From: Ian Stocks [REDACTED] **On Behalf Of** FRS Water and Access
Sent: 08 June 2021 16:53
To: Planning.Responses <Planning.Responses@arun.gov.uk>
Subject: Hydrant condition - AL/50/21/PL L'Apache Westergate Street Woodgate PO20 3SQ

HYDRANT CONDITION CONSULTATION WITH PLANNING AUTHORITY

Planning Ref: AL/50/21/PL

Description: Variation following grant of AL/103/18/PL to amend Condition No 2 approved plans - to change the design & layout of approved 2 No. dwellings.

Project:-	Proposed Residential Development L' Apache Westergate Street Woodgate Chichester		
Title:-	Block Plan		
Client:-	Randmere Limited		
Scale:-	1:500 (@A3)		
Drawn By:-	PJD	Checked By:-	
Date:-	23/04/21	Date:-	
Job.No:-	210005	Drg.No:-	02

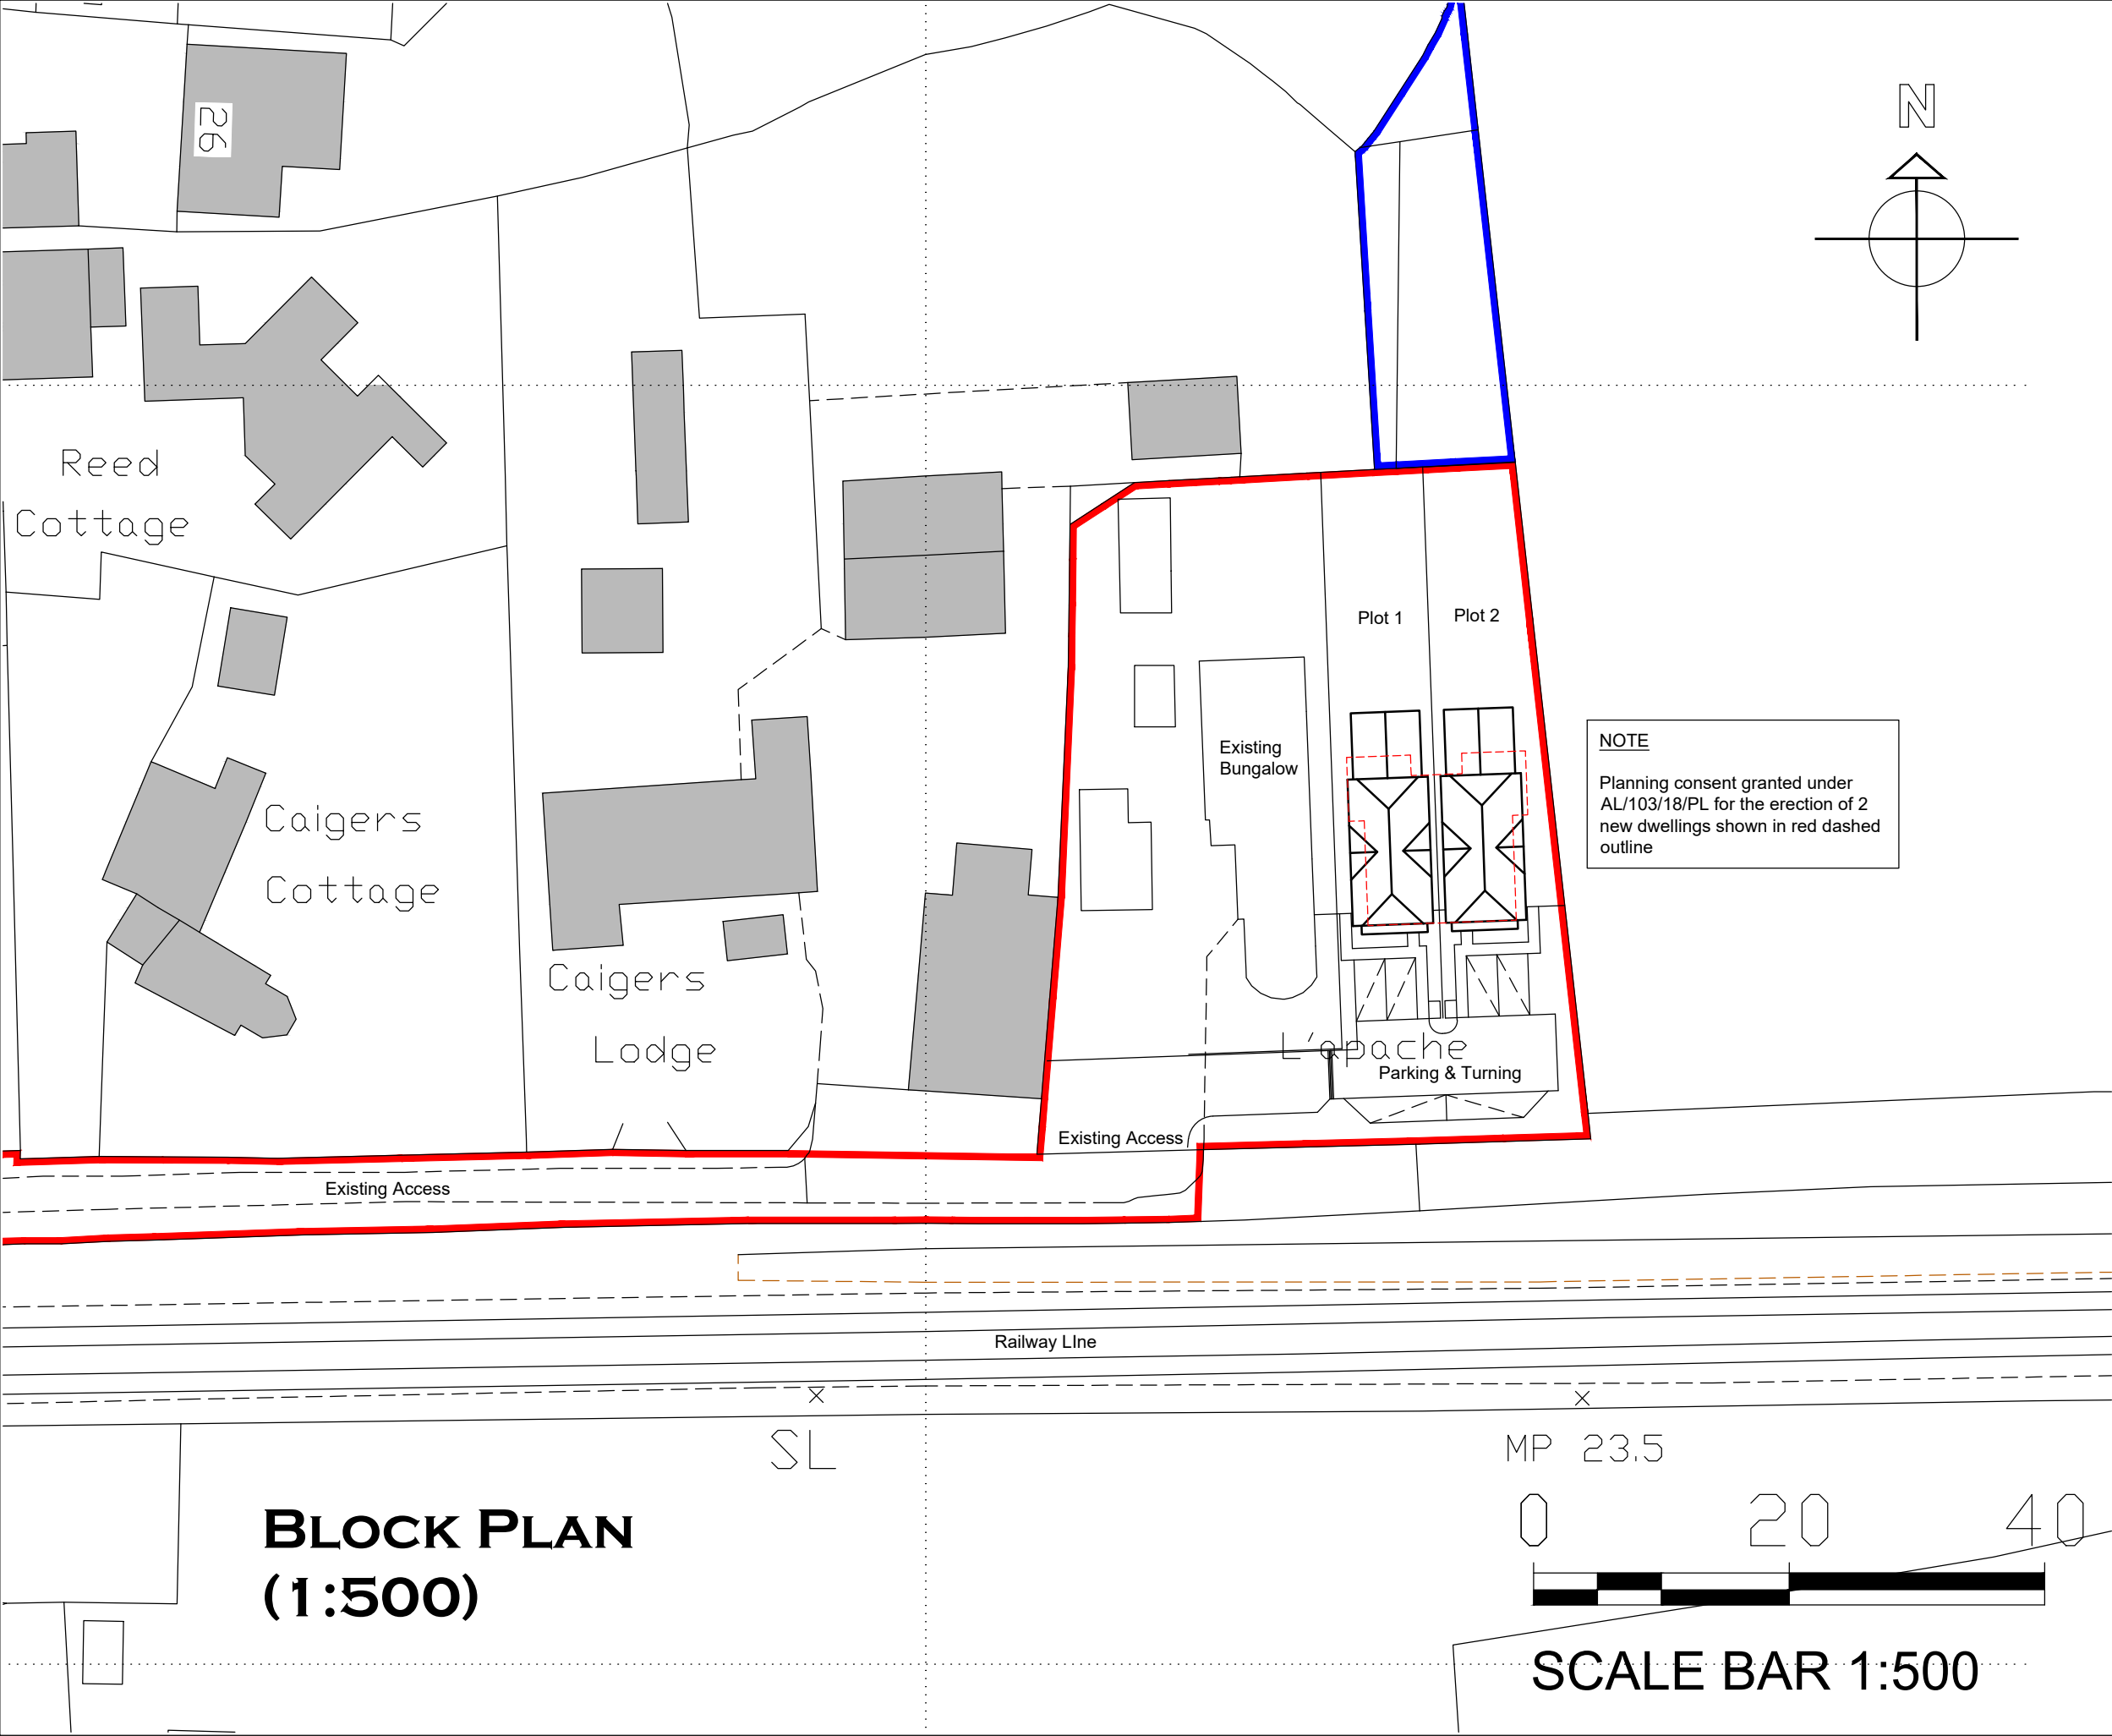
Please find attached a planning condition for application no. AL/50/21/PL for the requirement of an additional fire hydrant. Currently the nearest Hydrant to these proposed properties is 400 metres away. The supply of water for firefighting for a domestic premises should be within 175 metres.

Evidence will also be required that Fire Service vehicle access meets with the requirements identified in Approved Document B Volume 1 2019 Edition: B5 Section 13, including Table 13.1 and diagram 13.1. The plan submitted indicates the access route is too narrow for a Fire Appliance to gain access and also insufficient turning facility for a Fire Appliance to turn and make an exit.

- 1) Prior to the commencement of the development details showing the proposed location of [1] one fire hydrant or stored water supply (in accordance with the West Sussex Fire and Rescue Guidance Notes) shall be submitted to and approved in writing by the Local Planning Authority in consultation with West Sussex County Council's Fire and Rescue Service. These approvals shall not be unreasonably withheld or delayed.
- 2) Prior to the first occupation of any dwelling/unit forming part of the proposed development that they will at their own expense install the fire hydrant in the approved location to BS 750 standards or stored water supply and arrange for their connection to a water supply which is appropriate in terms of both pressure and volume for the purposes of firefighting.
